Rampion 2 Offshore Wind Farm

**Appendix N2 – Annex 1 to the Natural England Deadline 2 Submission**

**Natural England's Response to the Examining Authority's Written Questions arising out of Issue Specific Hearing 1 on Environmental Matters - Agenda Item 6 - South Downs National Park - Seascape and Visual Effects Q6, 1-3.**

Planning Inspectorate Reference: EN010117

Figure 15.51e
 Viewpoint 28: Cuckmere Haven Beach

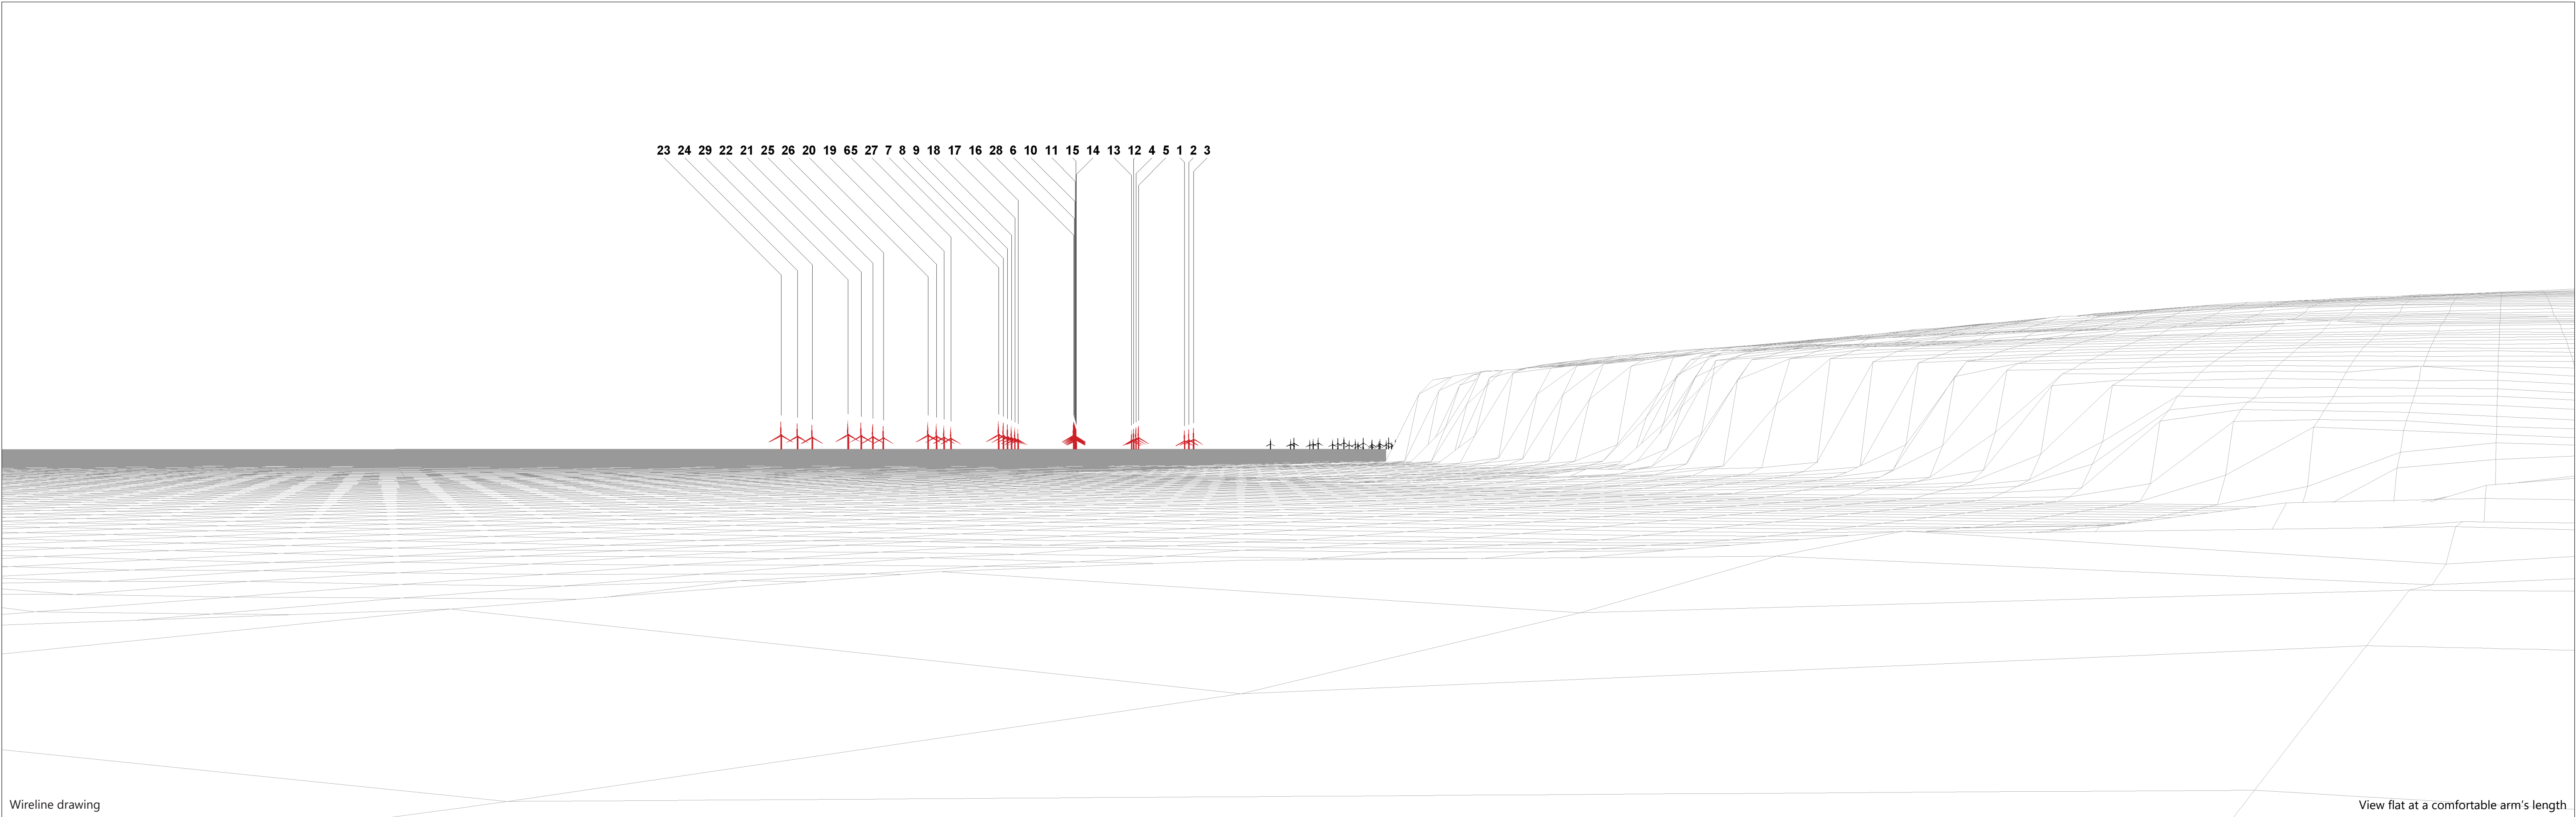
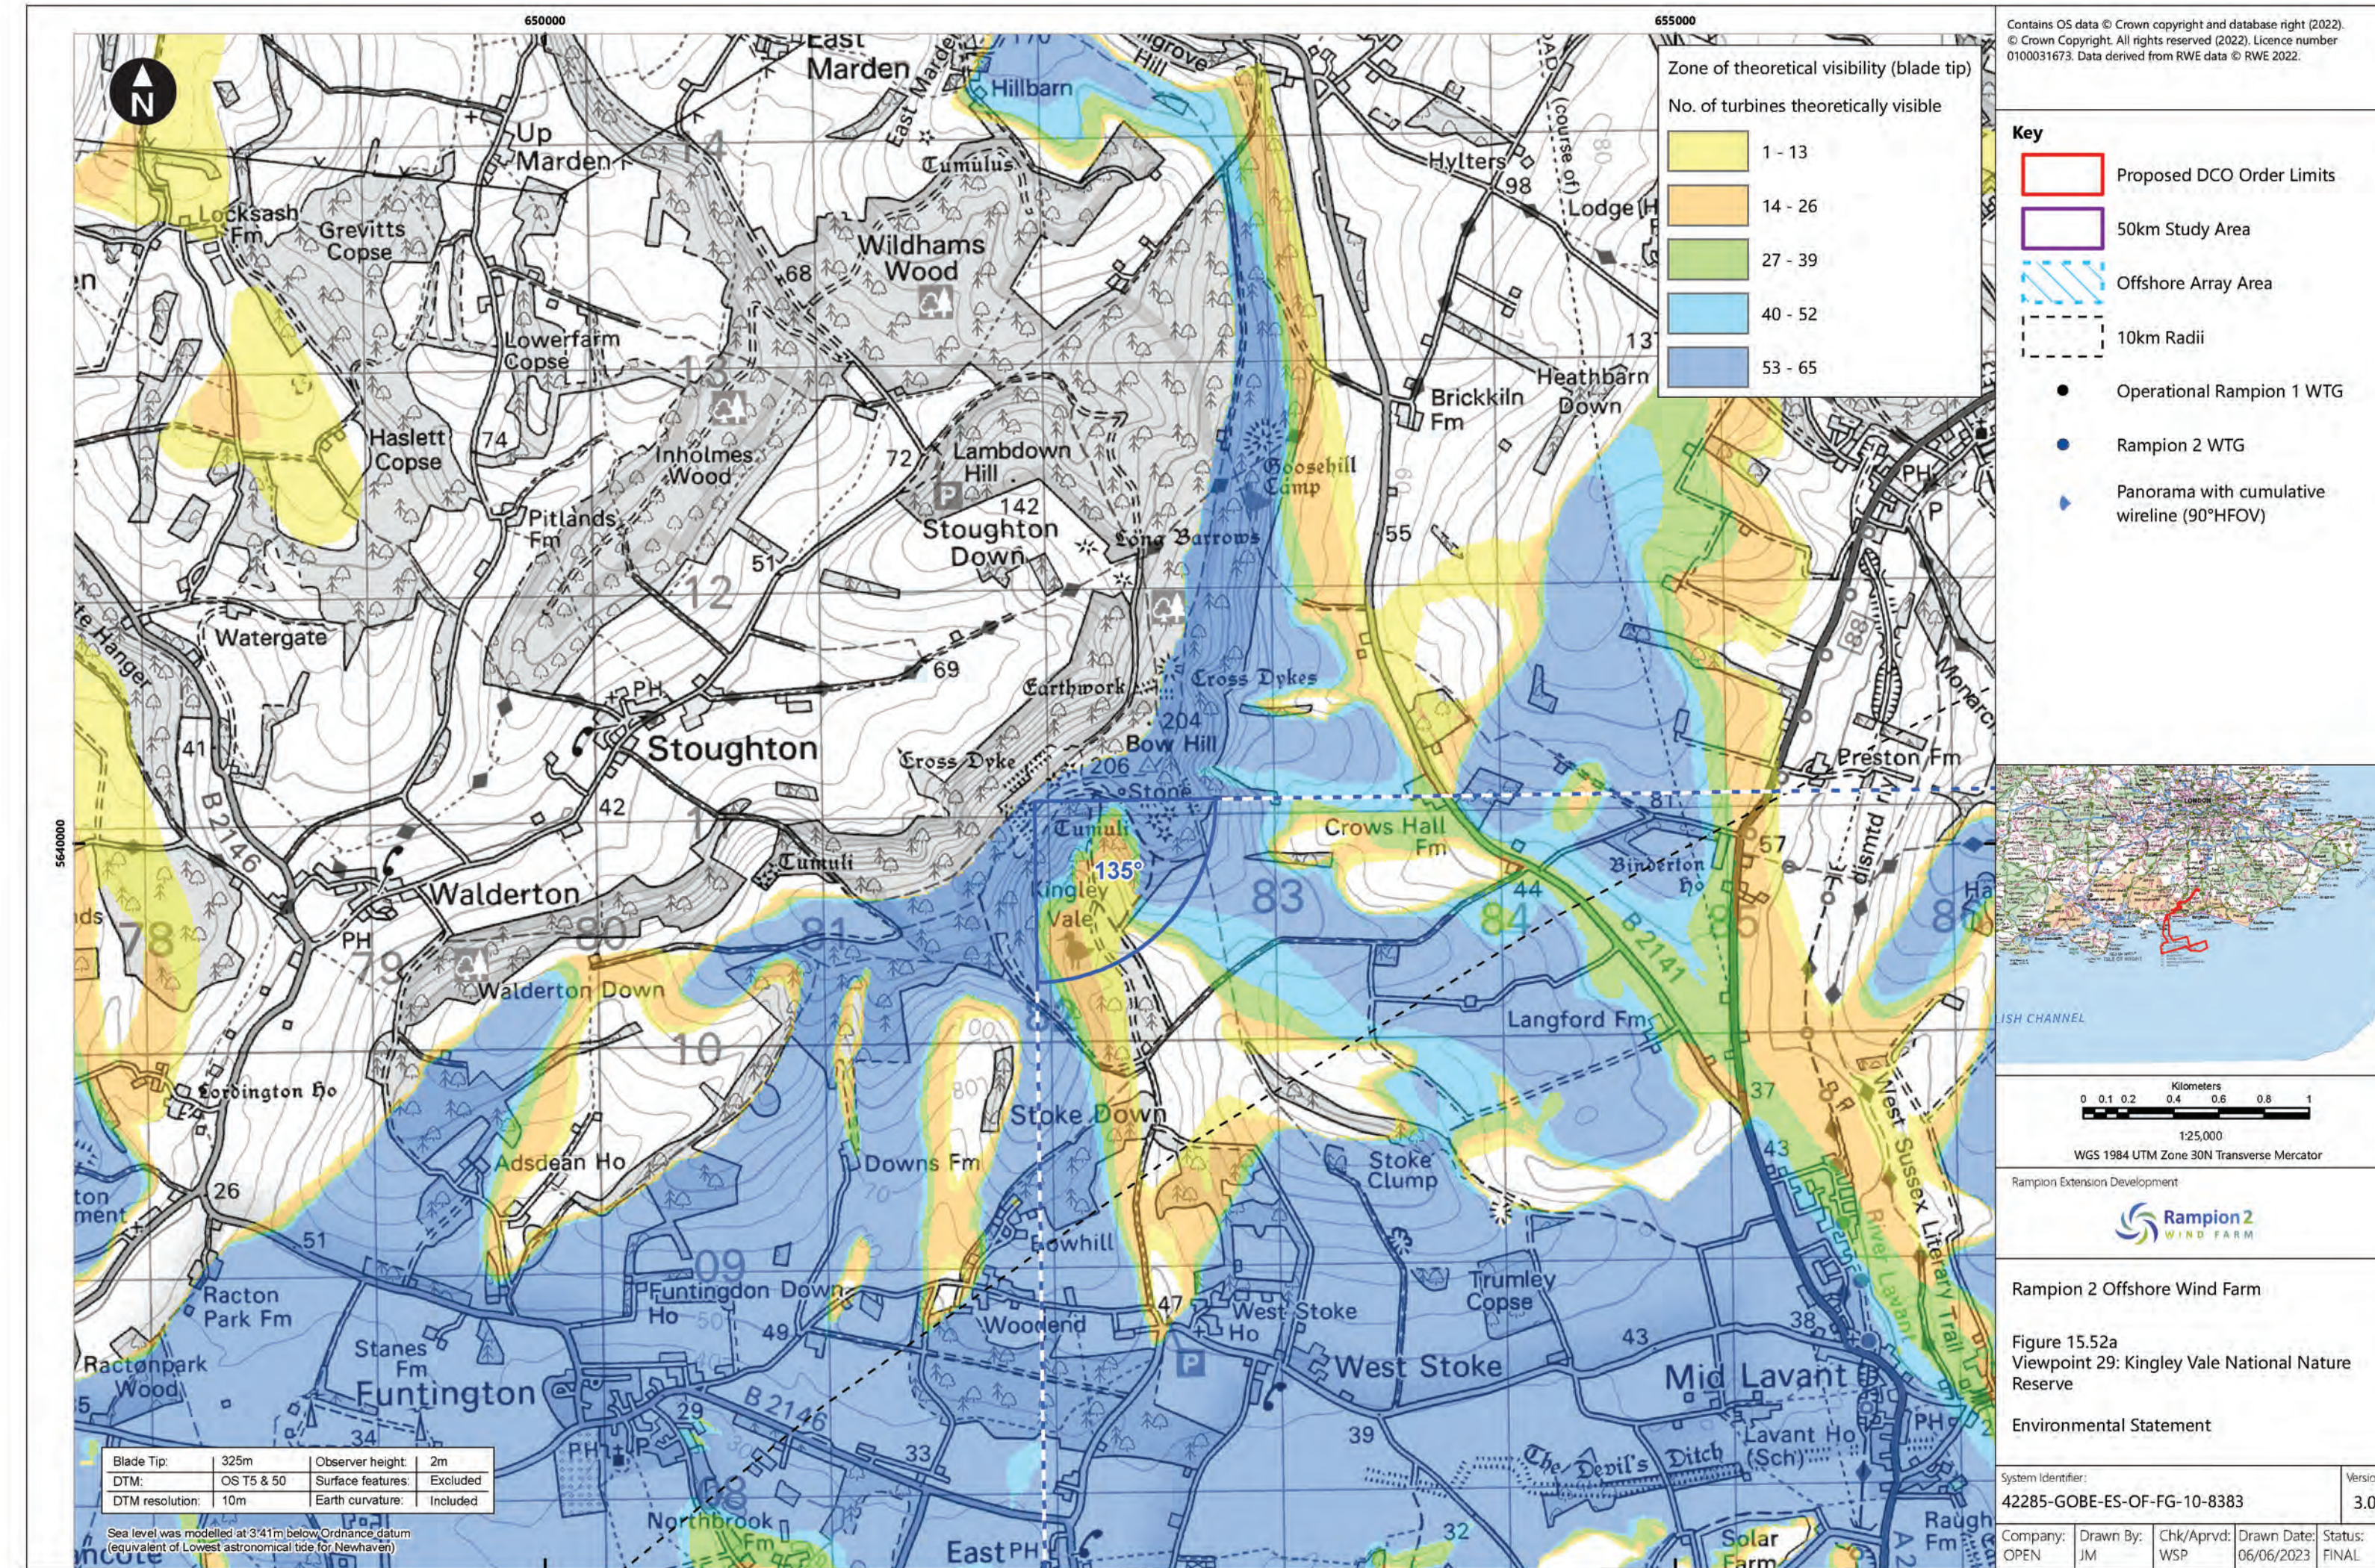
12. The Applicant also makes reference to the frequency that the Rampion 2 turbines would be visible. At a minimum a separation distance of the 19.5km (VP28 Cuckmere Haven Beach) the turbines of Rampion 2 are likely to be visible for 299 days a year; therefore not ‘infrequent’ as stated by the Applicant.
